**SUBMISSION re Environmental Impact Statement
for State Significant Development Application for M2 Site
in North Ryde Station Urban Activation Precinct, North Ryde (SSD 5093)
by John McCain and Diane Michel**

Site Plan

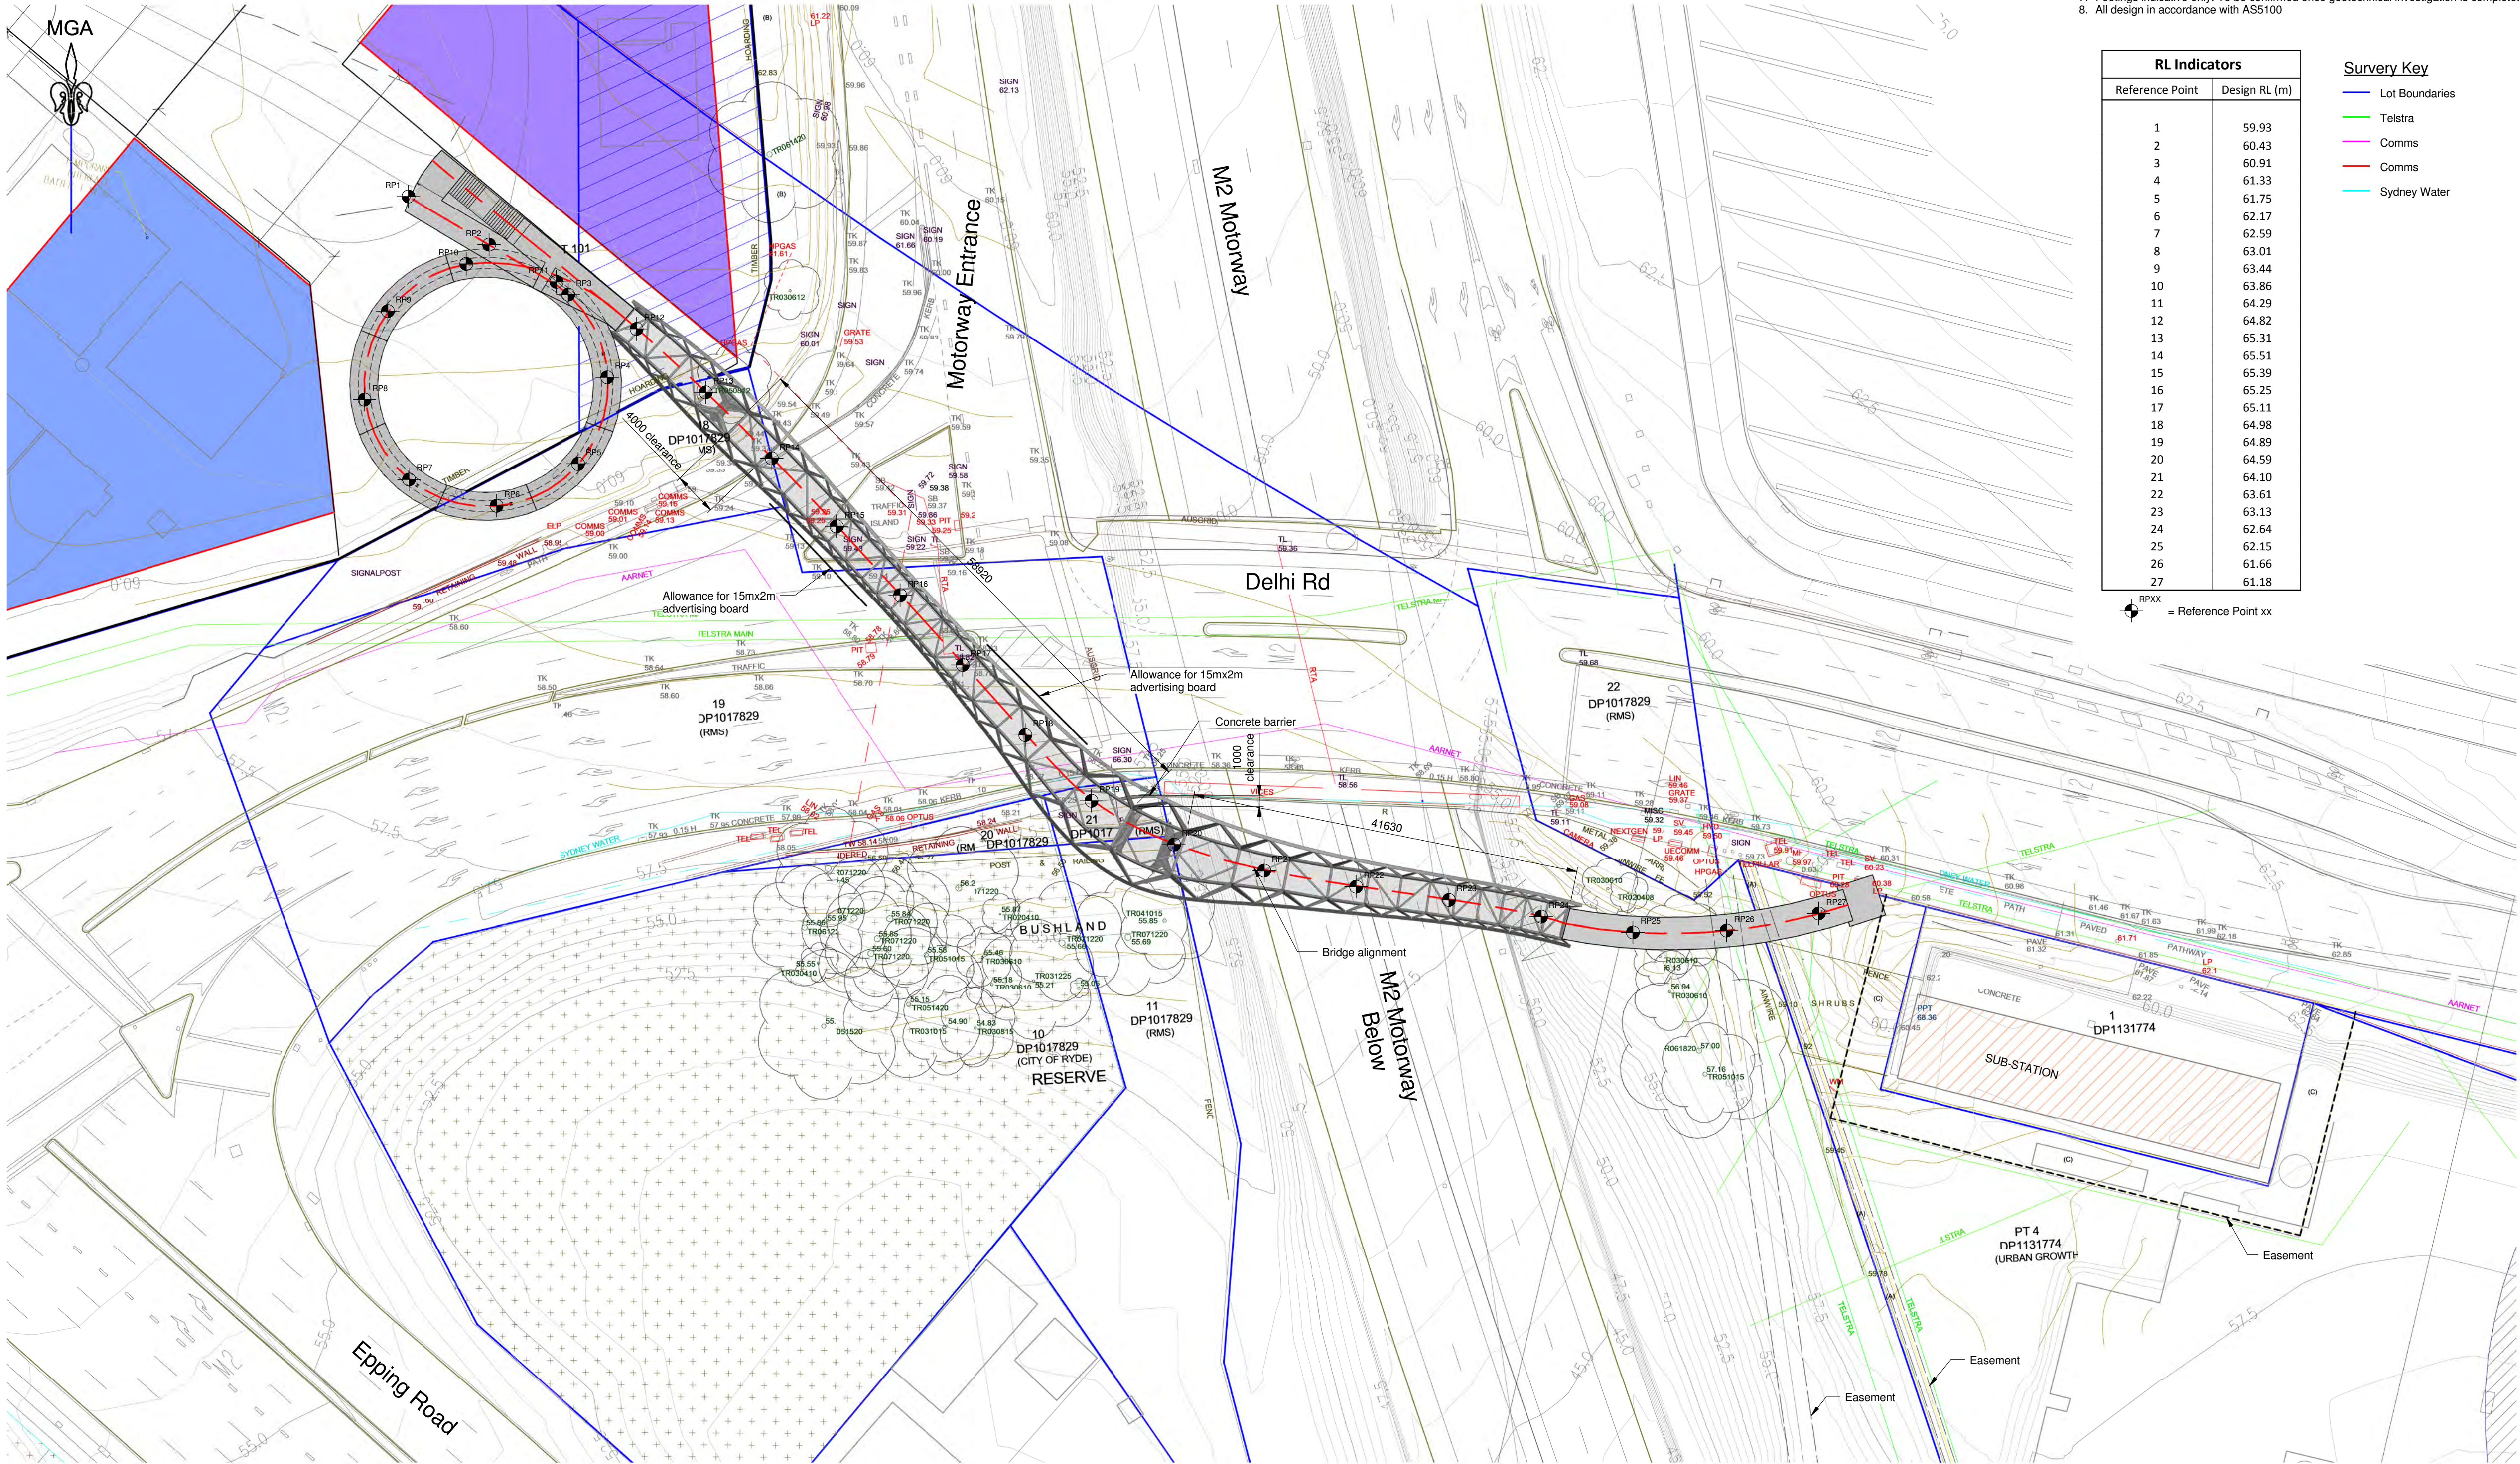
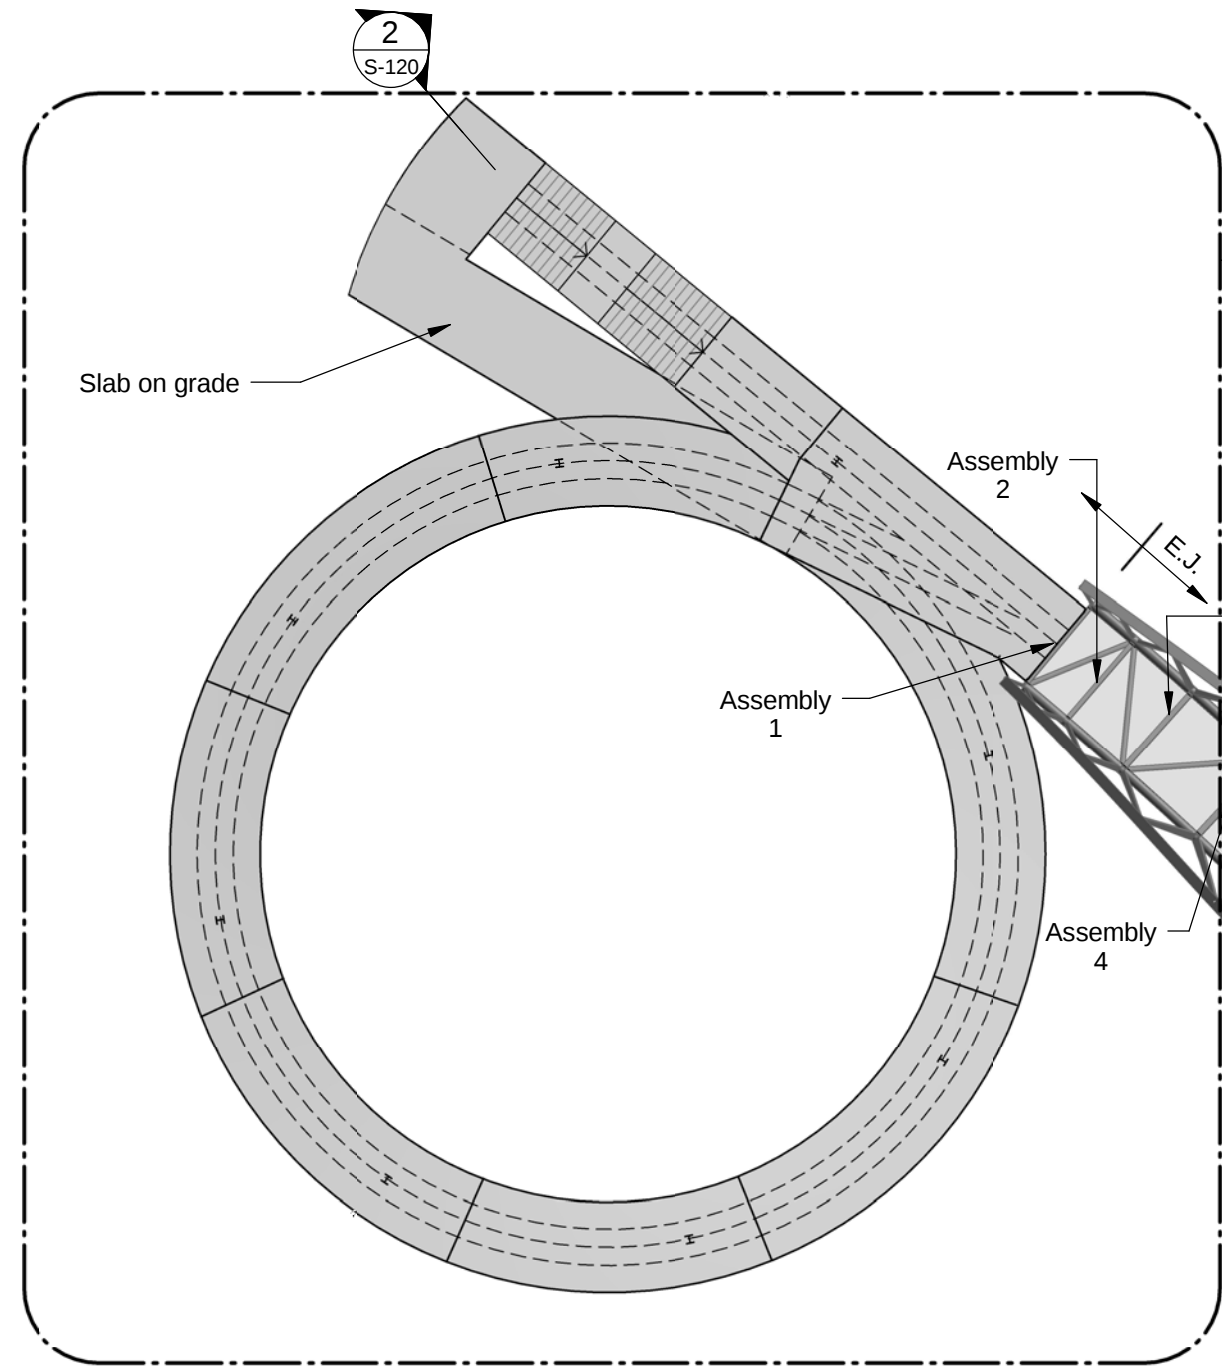
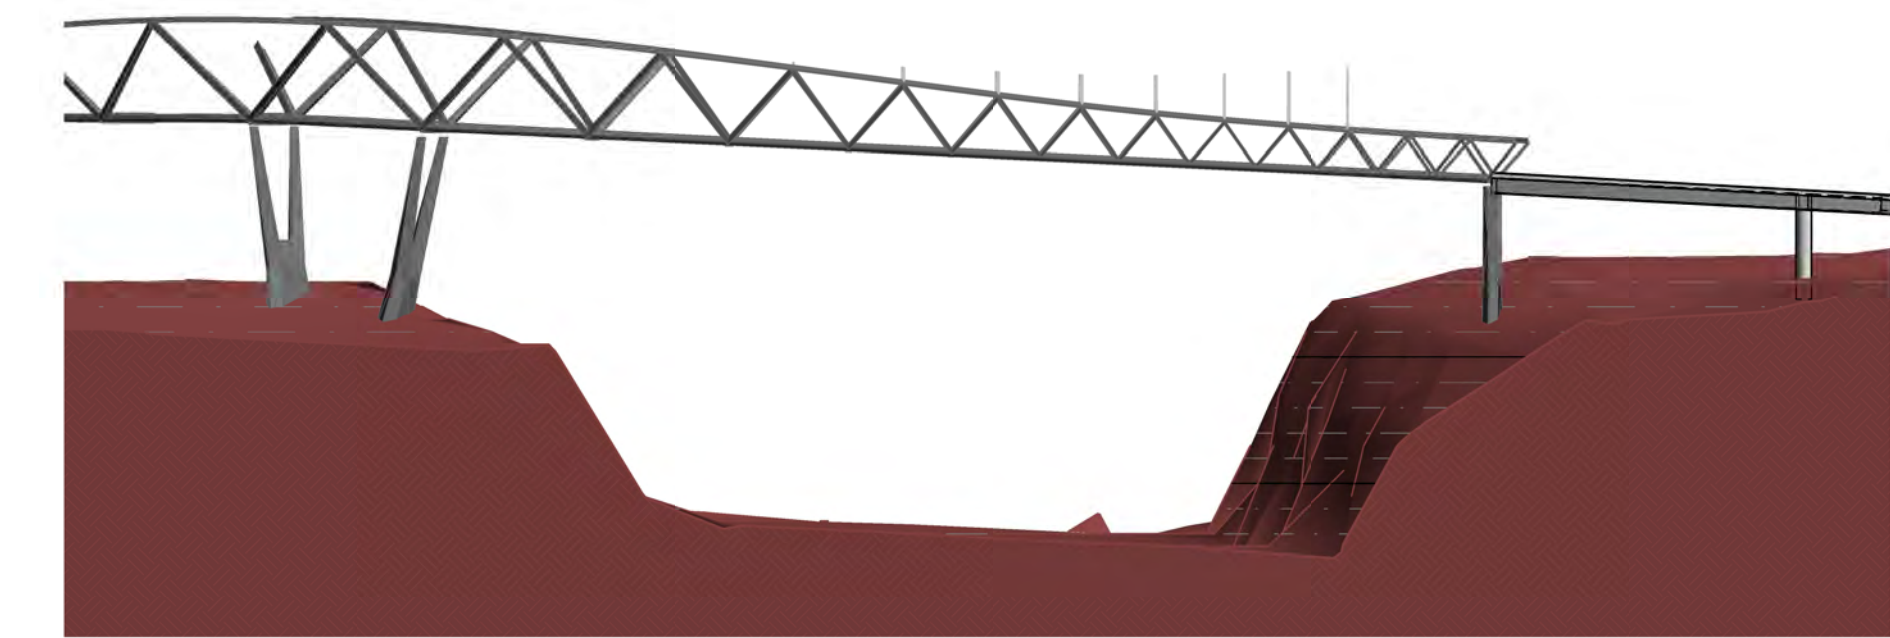
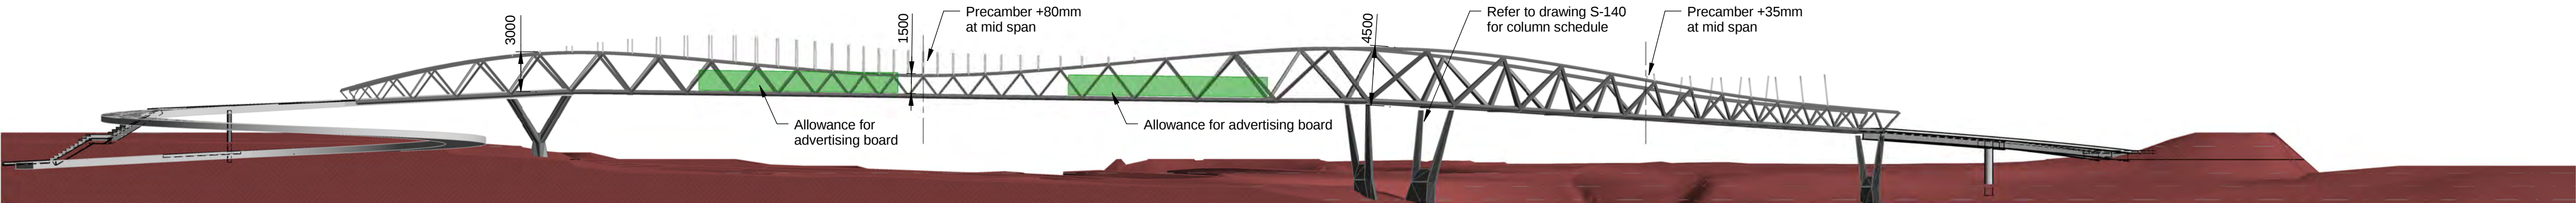
The bridge is more than outlined. A much-improved design is examined in considerable detail. Unfortunately, the bridge supports at two locations on the east side of Delhi Rd are not specified in the DGRs as part of the project Location. Although the bridge designers understood that the overhead crossing is a work associated with the project, consultants charged with environmental assessment took a differing view. Accordingly, there is no recognition of potential impacts on Bundara Reserve . . . and no suggestions for mitigation of inevitable impacts.

No visual (or safety) impact is predicted for a "15m x 2m advertising board" slung on the overbridge.⁴ (There is no denying that the purpose of the advertising is to create a 24-hour distraction for Delhi Rd motorists. There is no admission that such distractions are both ugly and hazardous. Existing and proposed on-road advertising at Delhi Rd is positioned near complex merge lanes, access ramps, etc, where accidents are already common. At night, the illuminated advertising on the M2's Delhi Rd bridge already is offensively visible from back windows on Epping Rd and within Bundara Reserve.)

⁴ Appendix B, structural drawing; North Ryde Pedestrian Bridge Urban Design Report Fig. 4.8.

The EIS provides neither assessment nor appropriate mitigation for potentially impacted sites near bridge supports on the eastern side of Delhi Rd (Bundara Reserve and Station North).
